**IVANHOE ESTATE - DEVELOPMENT CONSENT SSDA 8903**  
**CONDITION B41 – CONSTRUCTION PEDESTRIAN AND TRAFFIC MANAGEMENT PLAN**

**CONSTRUCTION PEDESTRIAN AND TRAFFIC MANAGEMENT PLAN**

**From:** Tim Saviane  
**Sent:** Tuesday, 22 December 2020 4:26 PM  
**To:** 'Mitch Ryan'; Yafeng (Alex) Zhu  
**Cc:** Peter Carruthers; Keith Peters; 'Adriana Malin'; Chris Koukoutaris; Peter Josevski; Peter Statham; Joe Avgoustis  
**Subject:** RE: SSDA 8903 - Ivanhoe Estate - Condition B41 - CPTMP  
**Attachments:** CTMP-LDA2017-0537 - Ivanhoe Estate, Macquarie Park NSW [R1.1]TS.pdf

6. APPENDIX A – TRAFFIC CONTROL PLANS

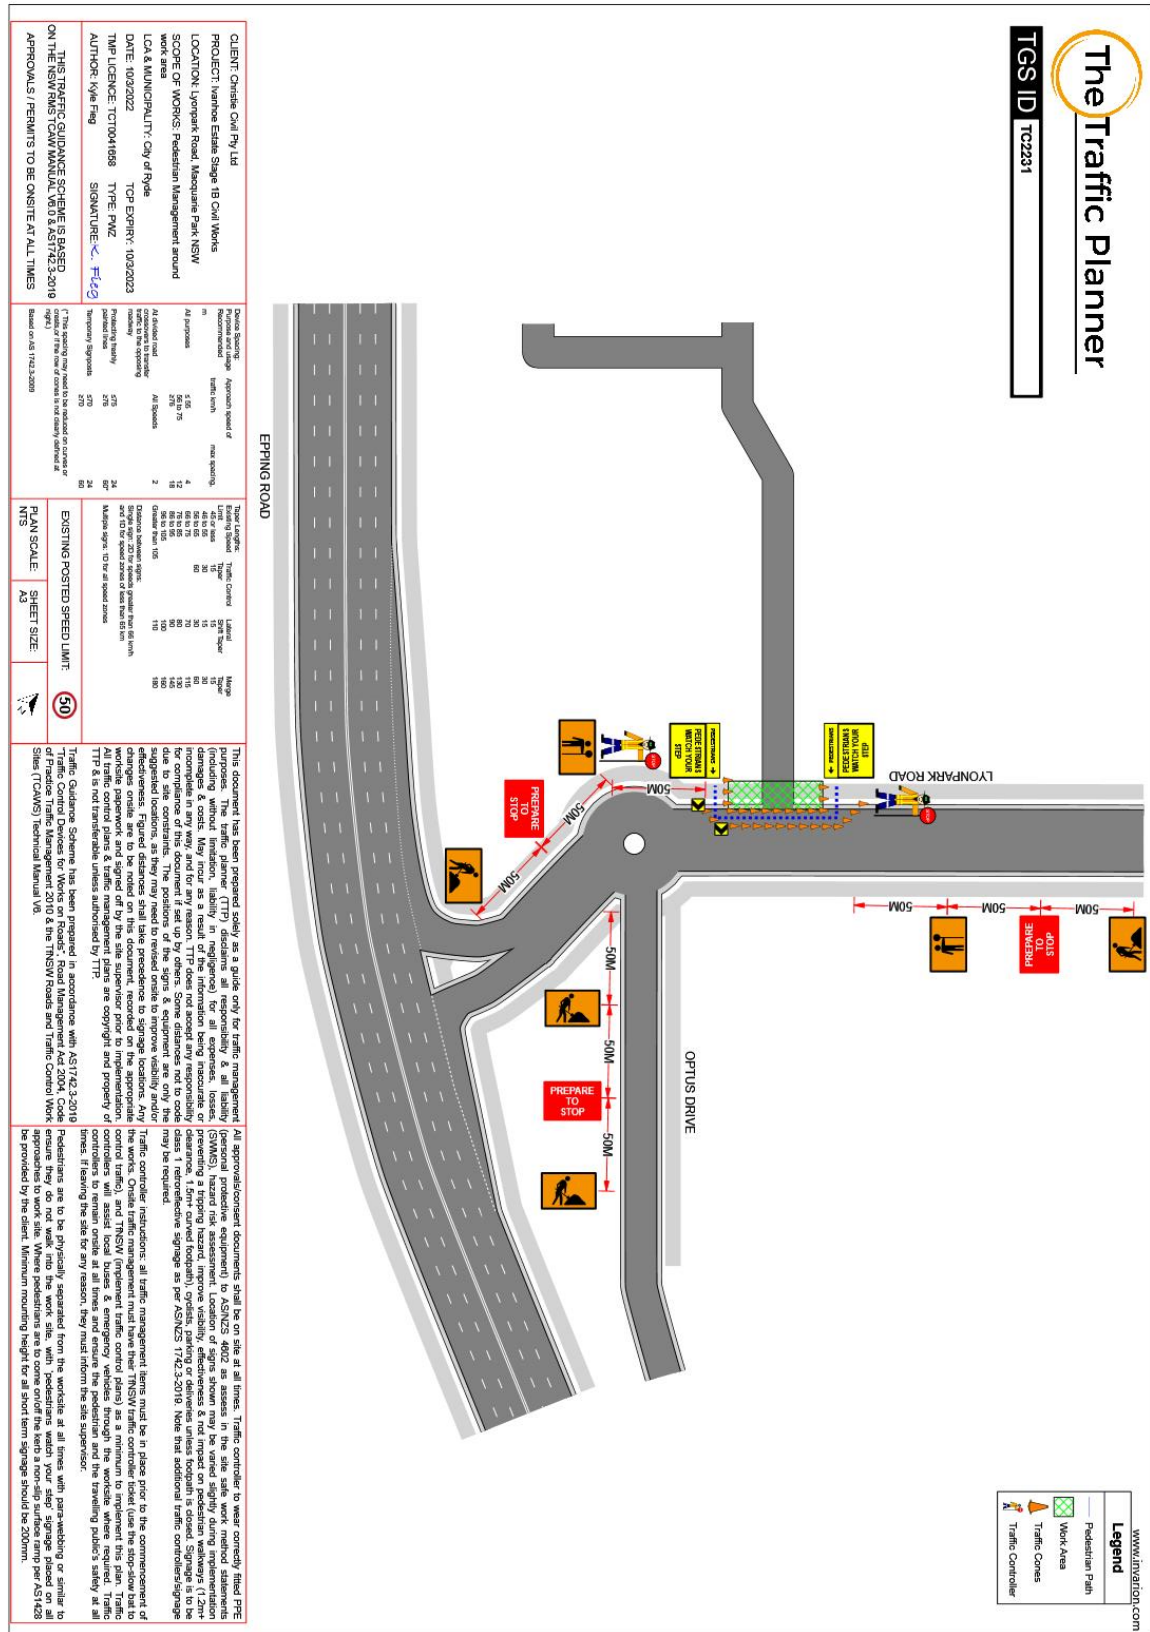
3. Swept paths is to be provided to demonstrate that the largest heavy/construction vehicle is able to undertake the following movements in a safe and efficient manner:

- o Right turn from Herring Road into Ivanhoe Place; and
  - o Left turn from Ivanhoe Place into Herring Road

3. Provision of detailed swept path analysis for ingress and egress to the site for the largest vehicle expected to use the roundabout on Herring Rd at Ivanhoe Pl. TfNSW is seeking to ensure the turns can be made without adverse impacts to the network;

3. Provision of detailed swept path analysis for ingress and egress to the site for the largest vehicle expected to use the roundabout on Herring Rd at Ivanhoe Pl. TfNSW is seeking to ensure the turns can be made without adverse impacts to the network;  
Refer to revised CPTMP Appendix 1
